From: Davis, Fern - Oxfordshire County Council <Fern.Davis@Oxfordshire.gov.uk>
Sent: Friday, August 23, 2024 10:33 AM
To: Laura Bell <Laura.Bell@Cherwell-DC.gov.uk>
Subject: Application No: 24/02058/F

In relation to the above planning application, Oxfordshire Fire and Rescue Service have the following comments to make:

PROPOSED SITE PLAN
1 : 200

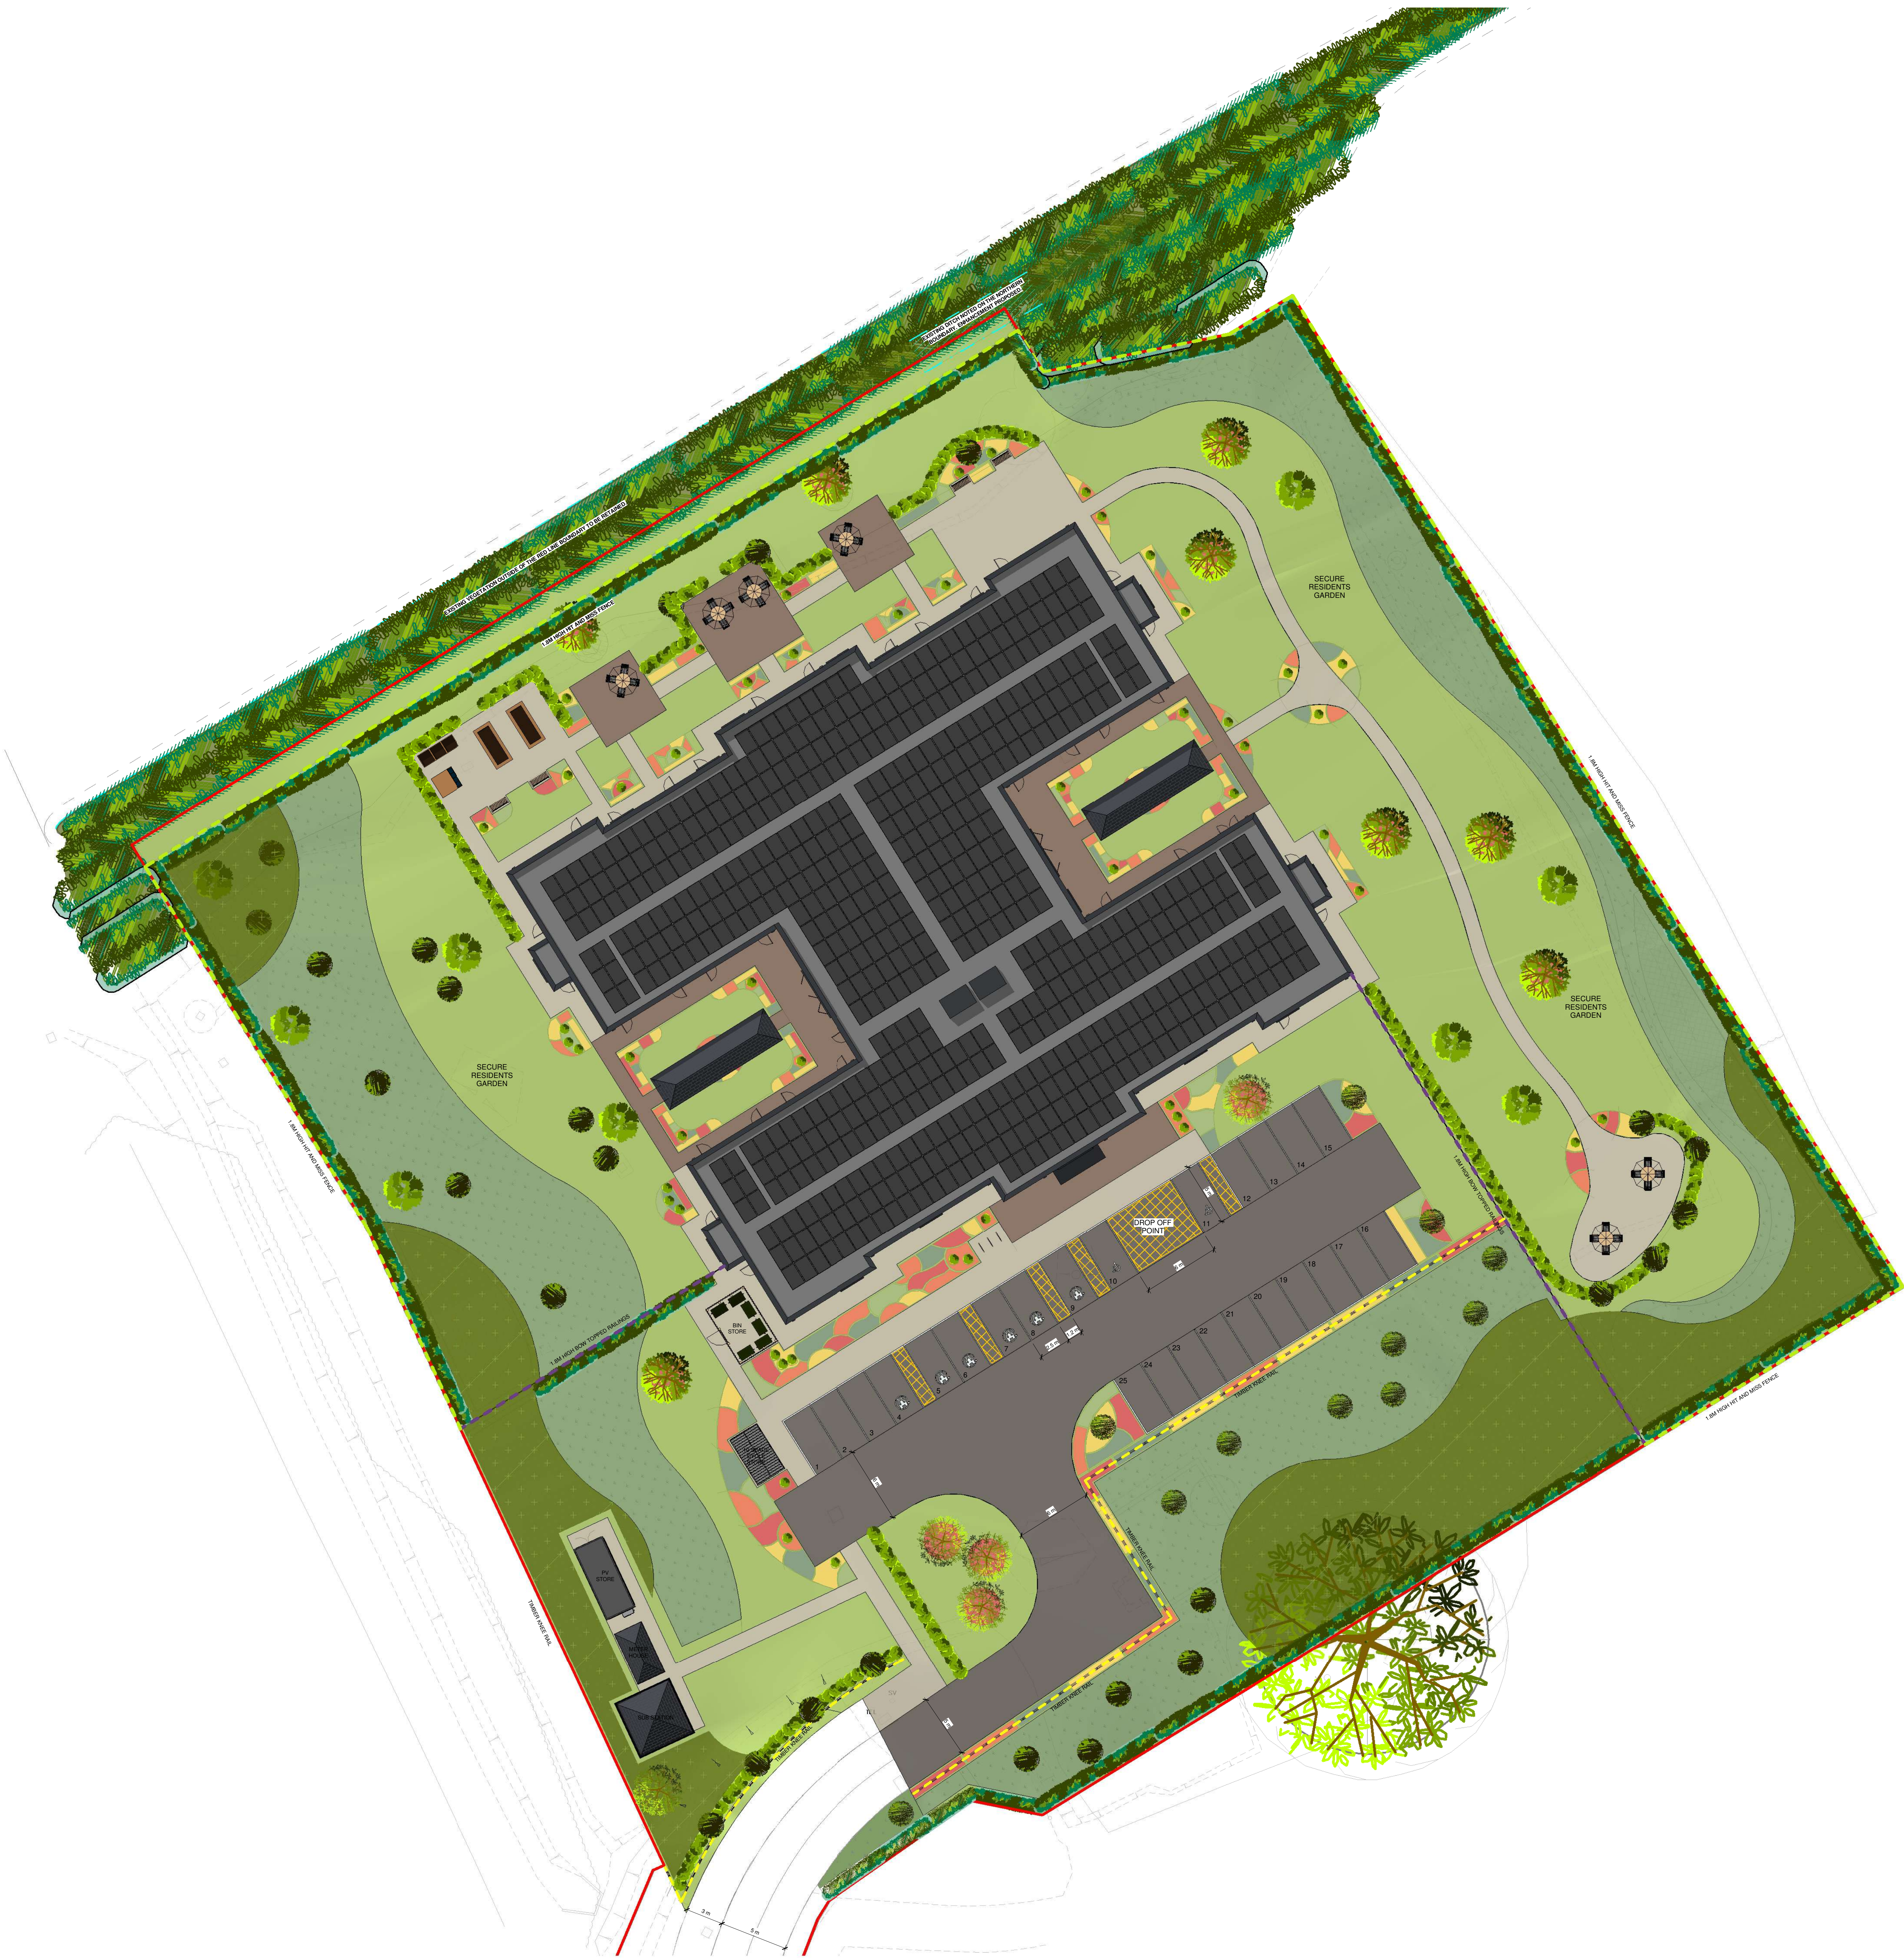
Site plans show limited access routes around the premises and a secure garden area. It should be ensured that suitable fire service access can be provided in accordance with Approved Document (B).
